Planning Application Reference No.: 3/2024/1025

Address of Development: Waddington Hall
Clitheroe Road

Comments: We are writing to you regarding the above application and wish to give some background information and comments to consider relating to the noise impact assessment.

Daytime Grid Noise Map

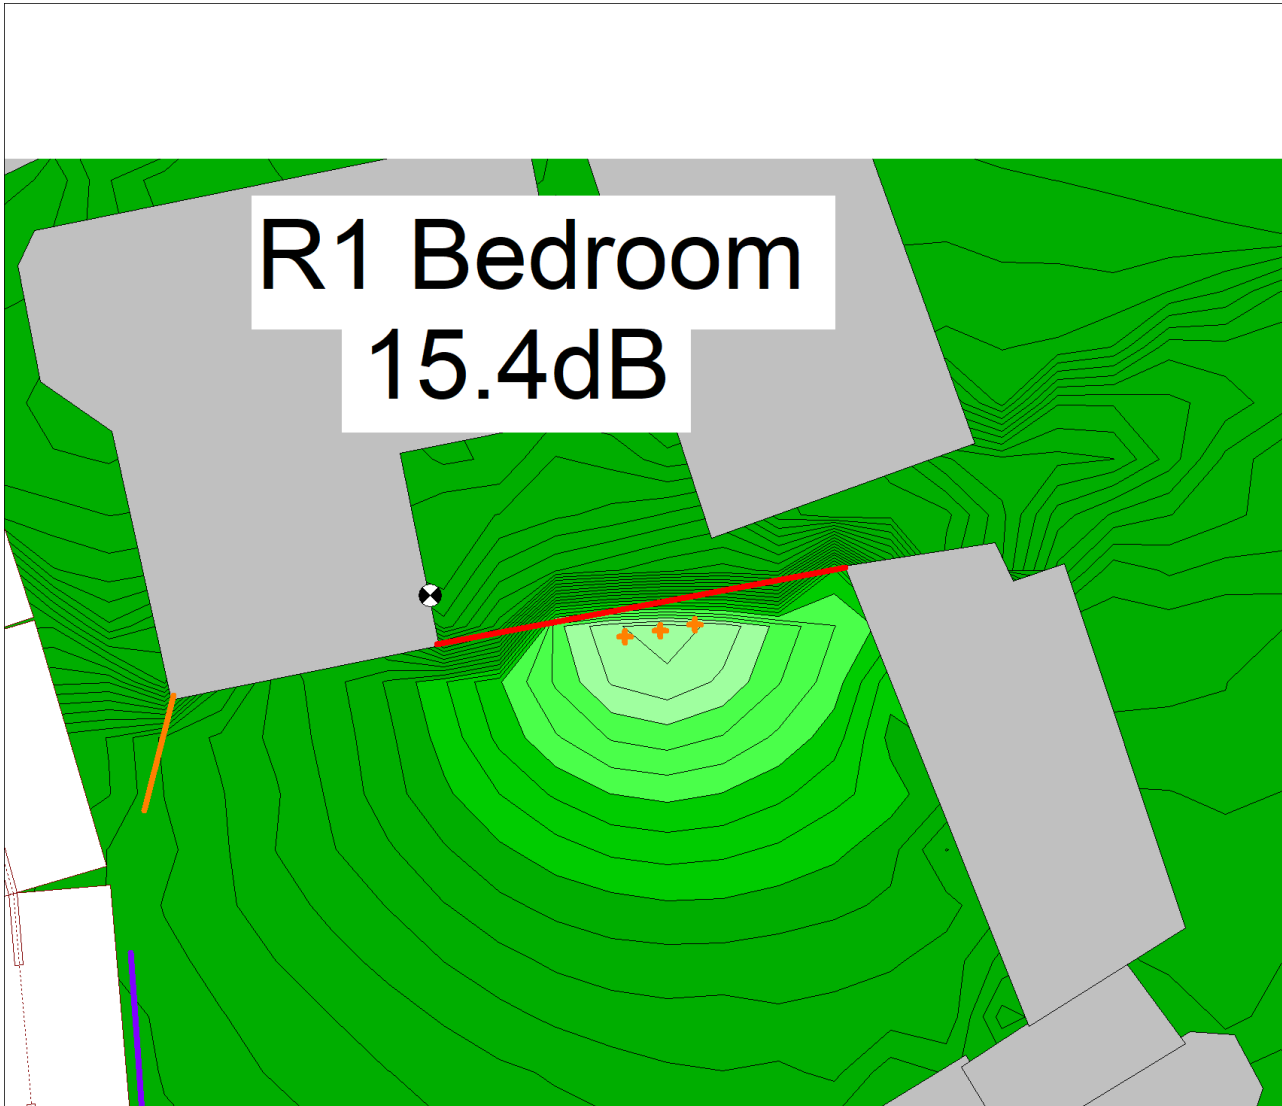
Background levels principally consist of traffic from the road which by its very nature is intermittent noise. The noise from three pumps could be constant.

Reference to decibel levels seems to be for one pump. No reference is made as to the cumulative effect of three pumps.
